**Conditions of development consent for the Sydney Metro Martin Place Station Precinct
SSD 9270 – North Site**

Condition B5, B6 and B7 discharge request #5 – Design excellence and design integrity review

1.0 Design changes – endorsement prior to Construction Certificate

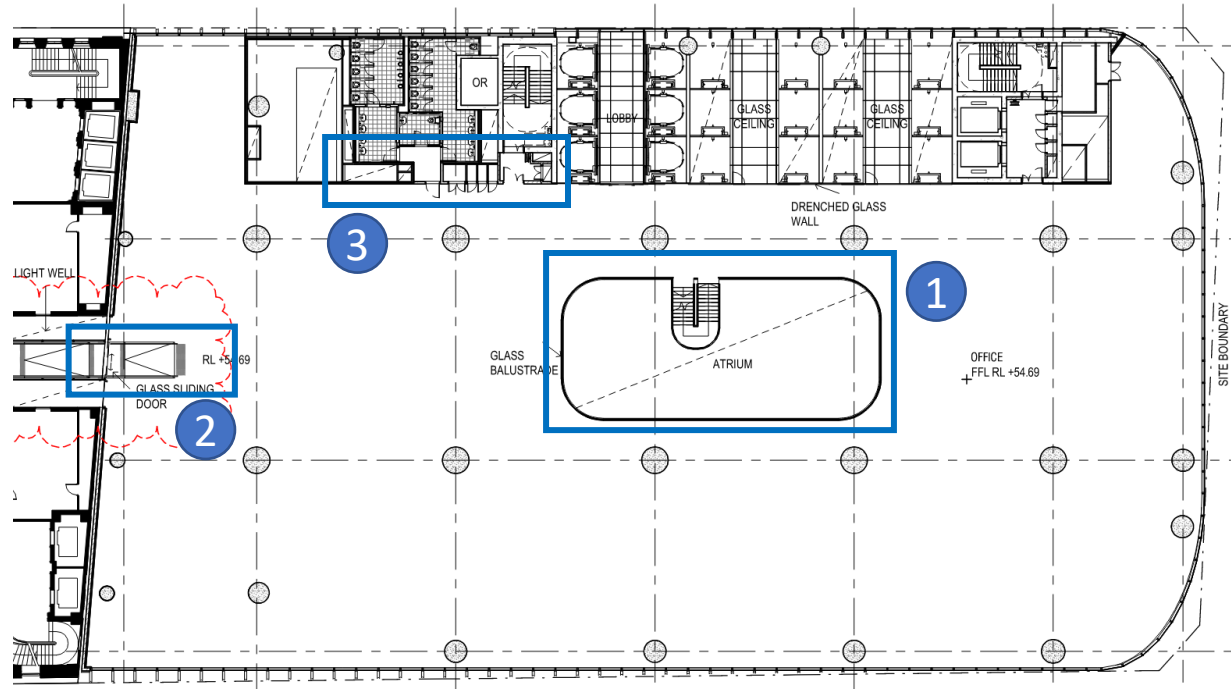
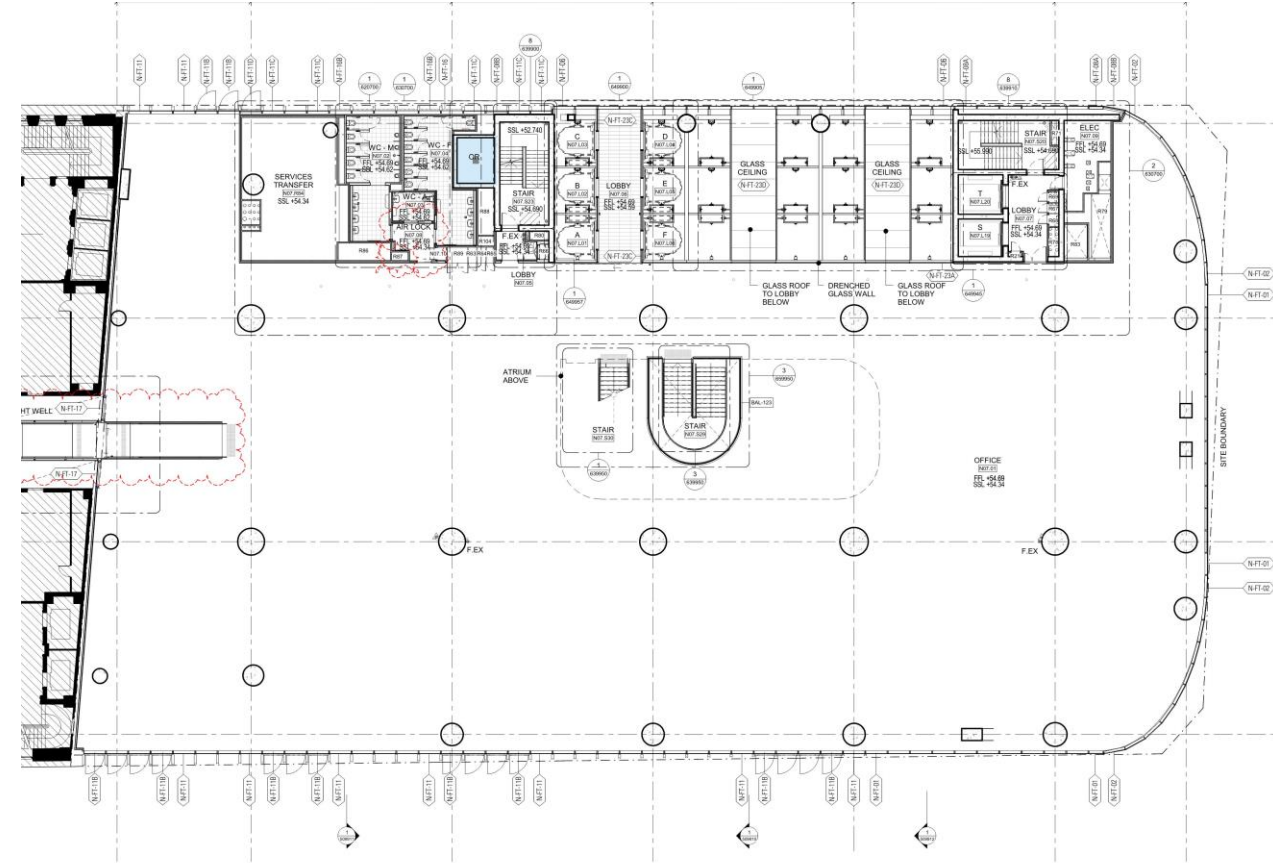
Attachment reference	Design change	OSD DRP engagement approach
Level 7		
Slide 2	Revised inter tenancy stair design and positioning.	OSD DRP review is not considered necessary on the basis the proposed changes are very minor, wholly internal and will not result in any changes to the building exterior.
	Revised internal ramp design (connecting to Level 7 bridge).	
	Revised back of house configuration.	
Level 8		
Slide 3	Revised atrium and inter tenancy stair design and positioning.	OSD DRP review is not considered necessary on the basis the proposed changes are very minor, wholly internal and will not result in any changes to the exterior of the building.
	Revised ramp design (connecting to Level 8 bridge).	
	Revised back of house configuration.	
Level 9		
Slide 4	Revised atrium and inter tenancy stair design and positioning.	OSD DRP review is not considered necessary on the basis the proposed changes are very minor, wholly internal and will not result in any changes to the exterior of the building.

Level 10 Plan

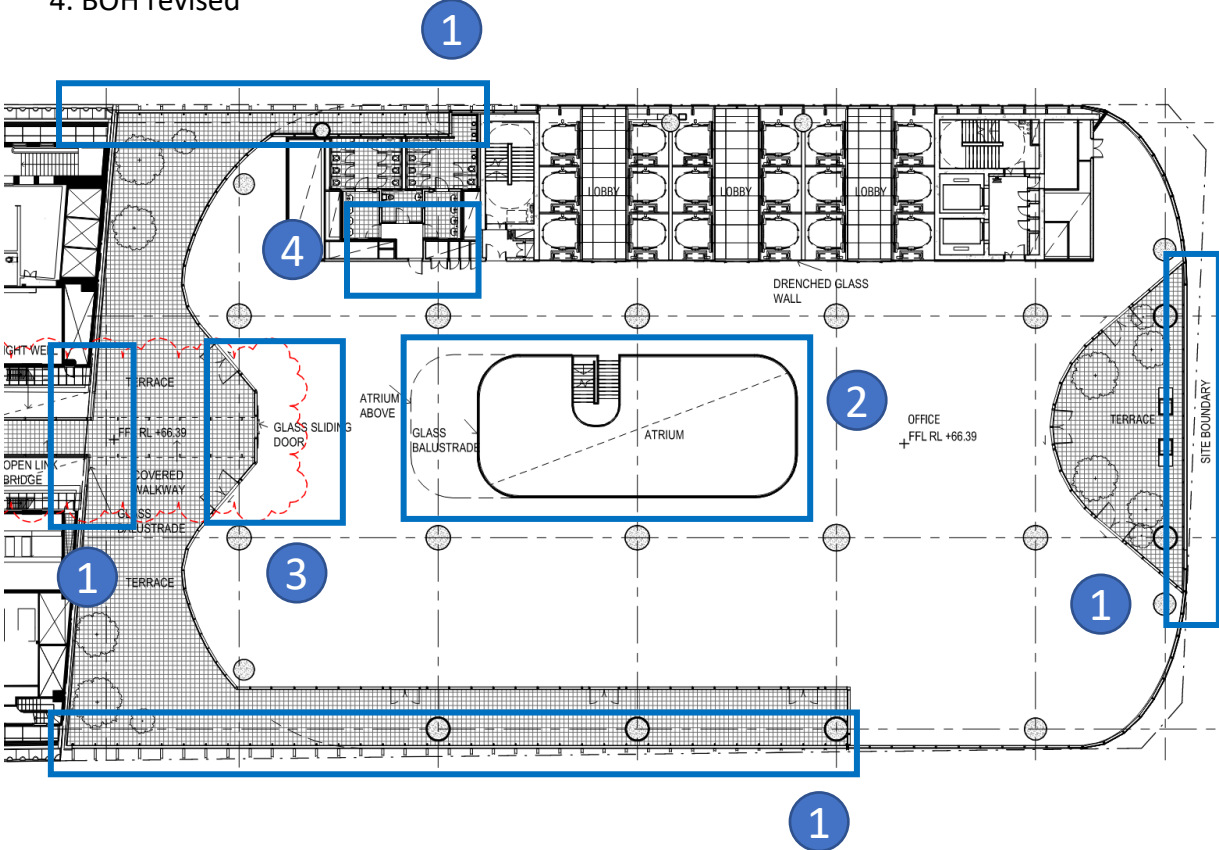
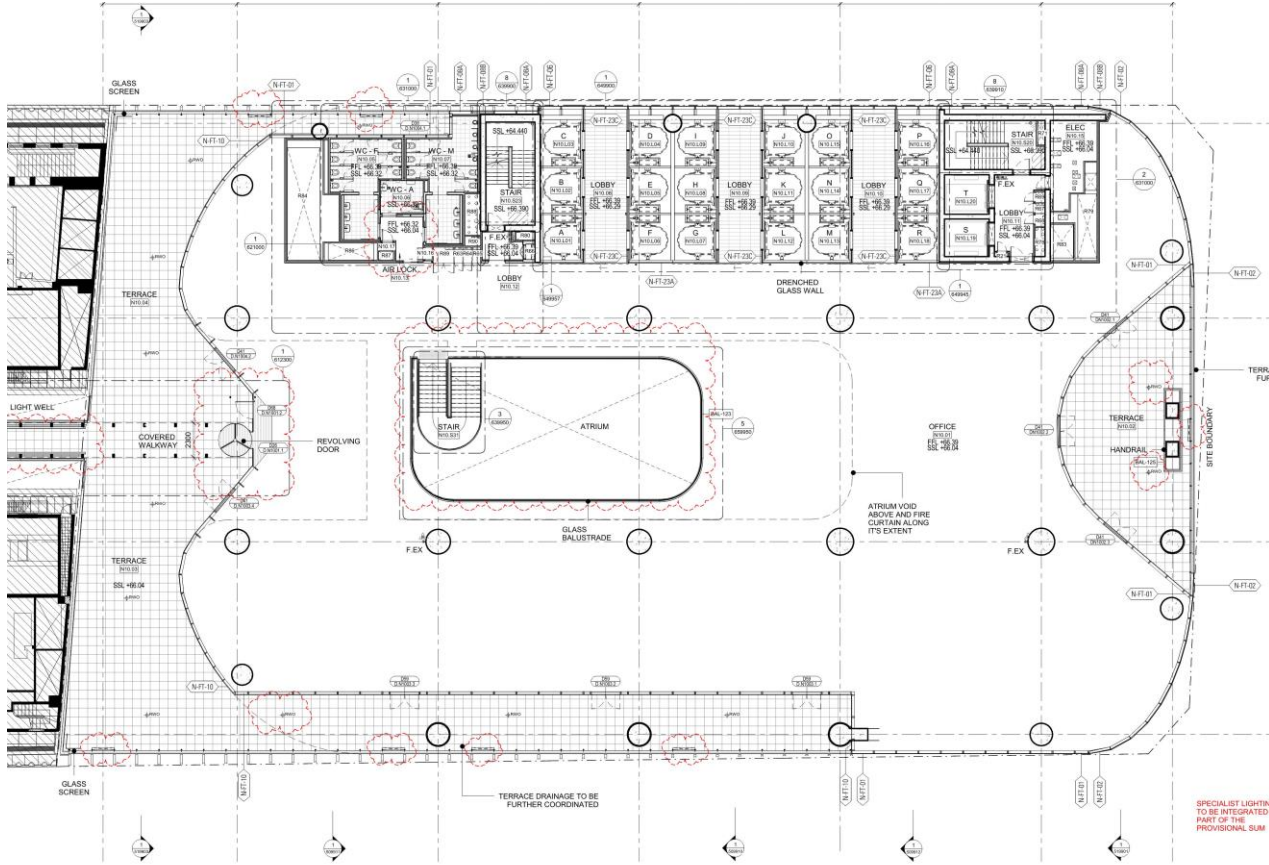
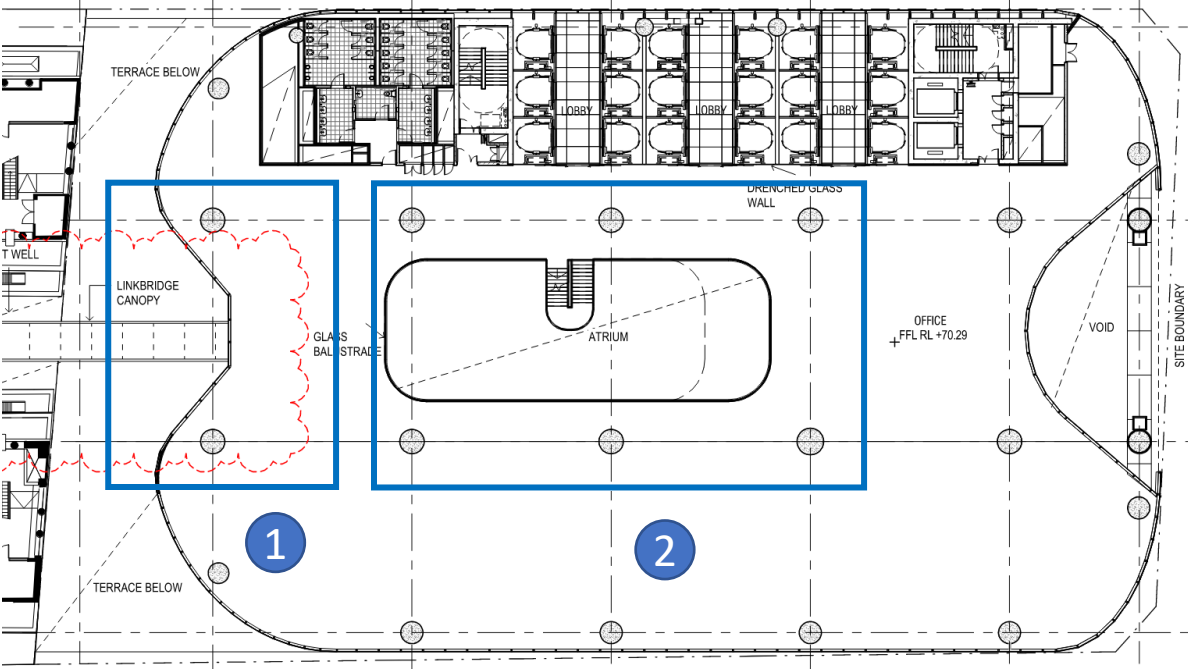
Revised back of house configuration.	
Level 10		
Slide 5, 6 and 36	Balustrade height increase from 1375mm to 1800mm along terrace edges on northern, eastern, western and southern elevation (adjacent 50MP).	OSD DRP review is not considered necessary given: <ul style="list-style-type: none">the proposed change relates to a minor increase in the height of balustrades, and the height increase of 425mm will not be perceptible from the public domain.The increase is considered acceptable as it is subject to a glass materiality which will cause minimal visual impact and will also provide tenants using the outdoor balcony greater safety.
	Revised atrium and stair design and positioning.	
	Sliding door replaced by revolving door.	
	Revised back of house configuration.	
Level 11		
Slide 7	Revised atrium and inter tenancy stair design and positioning (already approved void in centre of floor plate).	OSD DRP review is not considered necessary on the basis the proposed changes are very minor, wholly internal and will not result in any changes to the exterior of the building.

Level 11 Plan

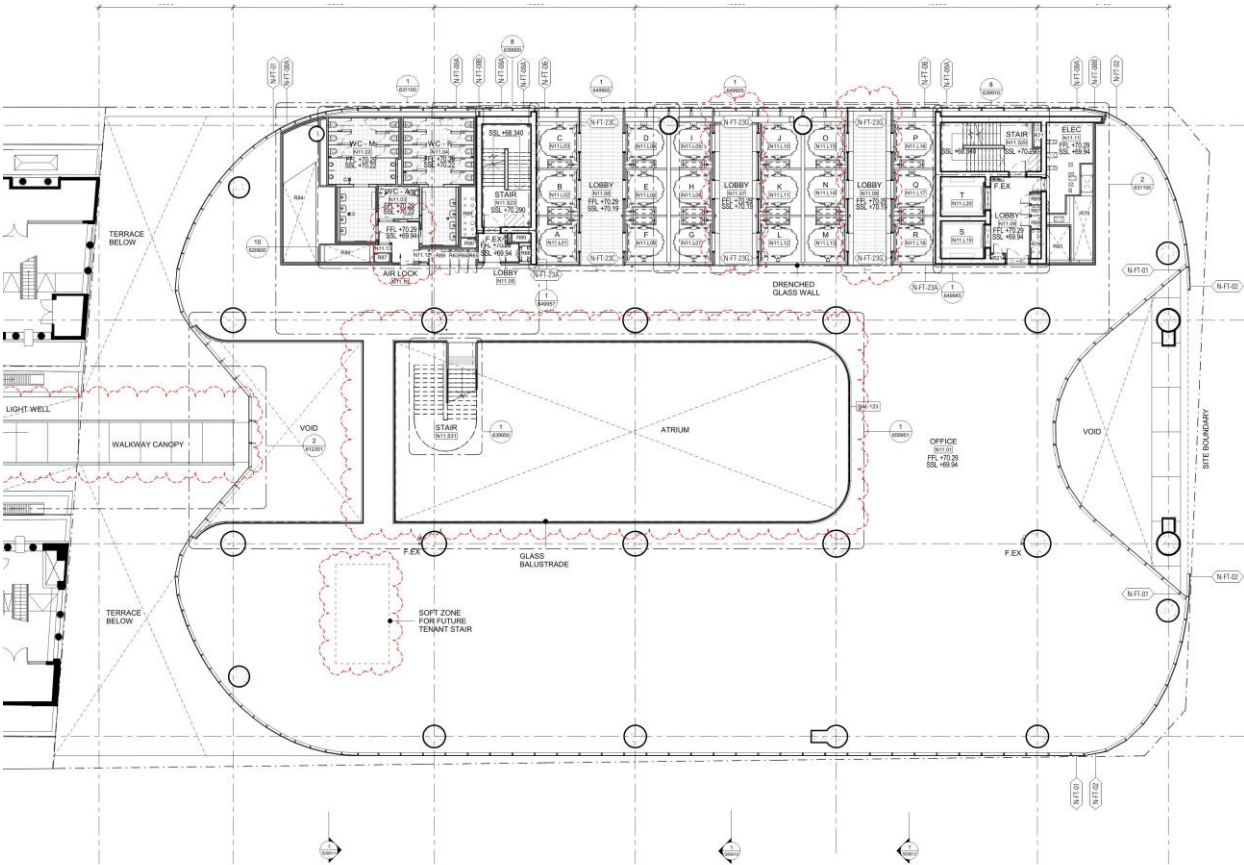
Attachment reference	Design change	OSD DRP engagement approach
	Inclusion of one additional void along southern edge of Level 11 floor plate.	OSD DRP review is not considered necessary on the basis the proposed void along the southern portion of Level 11 is located within the middle of the tower floor plate and will not be visible from the public domain. The void will improve the appearance of the façade and create further internal amenity.
Levels 12-14		
Slide 8-10	Revised atrium and inter tenancy stair design and positioning.	OSD DRP review is not considered necessary on the basis the proposed changes are very minor, wholly internal and will not result in any changes to the exterior of the building.
Level 15		
Slide 11	Revised back of house configuration.	OSD DRP review is not considered necessary on the basis the proposed changes are very minor, wholly internal and will not result in any changes to the exterior of the building.
